Project Name: **TIMOTEO CHAVEZ ADDITION**

ITEM # 14

PROJECT # 1003166

RE: Tracts K & R, Timoteo Chavez Addition/sketch

MIDTOWN STORAGE		
SCALE: 1" = 30'	APPROVED BY:	MARTIN BUCKLAND
DATE:	REVISION:	
4233 CUTLER AVE. N.E.		
SITE PLAN	DRAWING NUMBER	S - 1

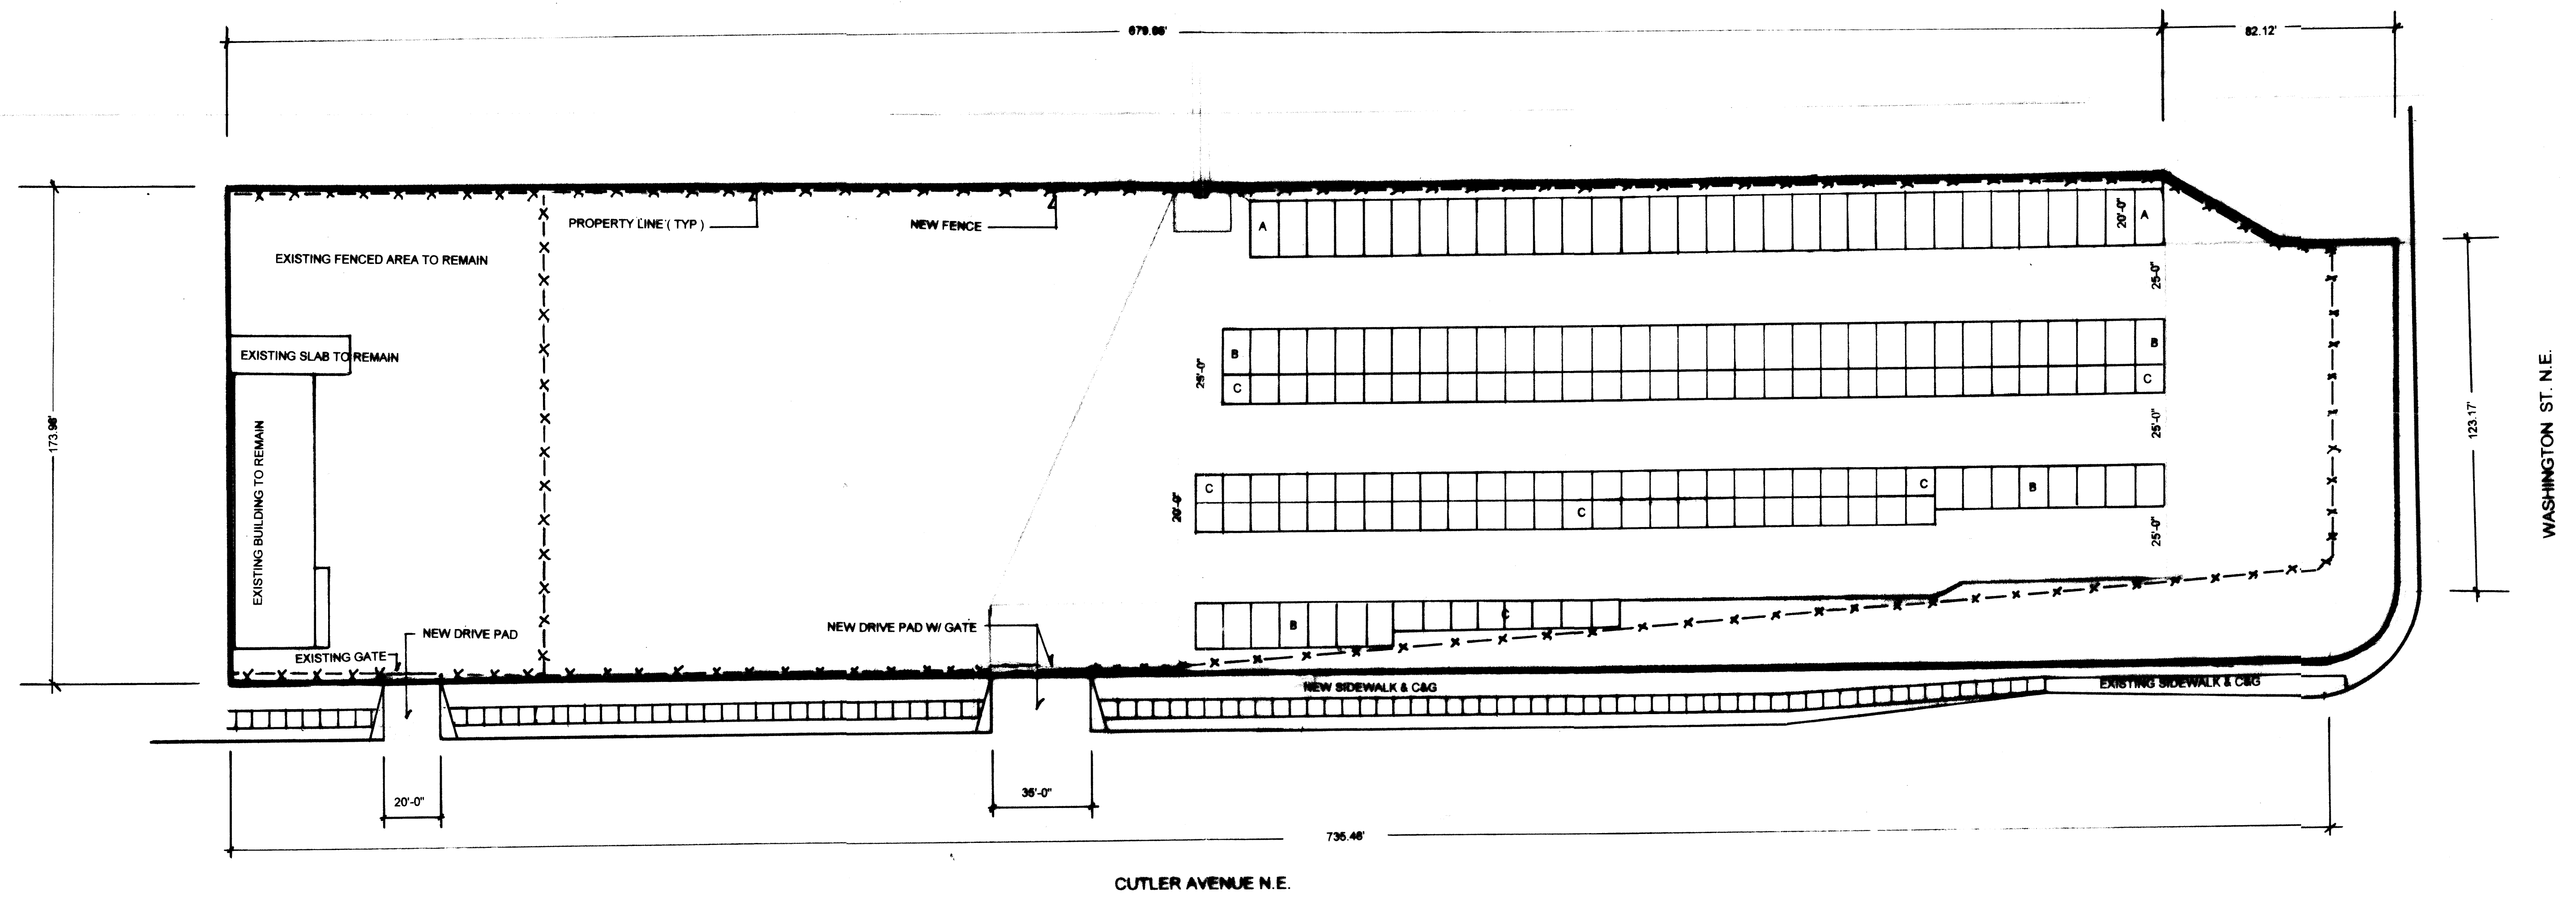
Mini storage is a form of warehousing & is a permissive use in this zoning.

Must drain to Cutler.

No.	Comment
1	INFRASTRUCTURE HAS TO BE REQUIR'D TO MEET DPM STANDARDS
2	NEED TO IDENTIFY VERTICAL ACTION FOR ALL DISPOSITION THROUGHOUT THE PROPERTY
4	PROVIDE PRELIMINARY PLAT w/ INFRASTRUCTURE LIST. 40' F-F PMT.
5	CUTWAL REQUIRES BLUE TRAIL/PATH
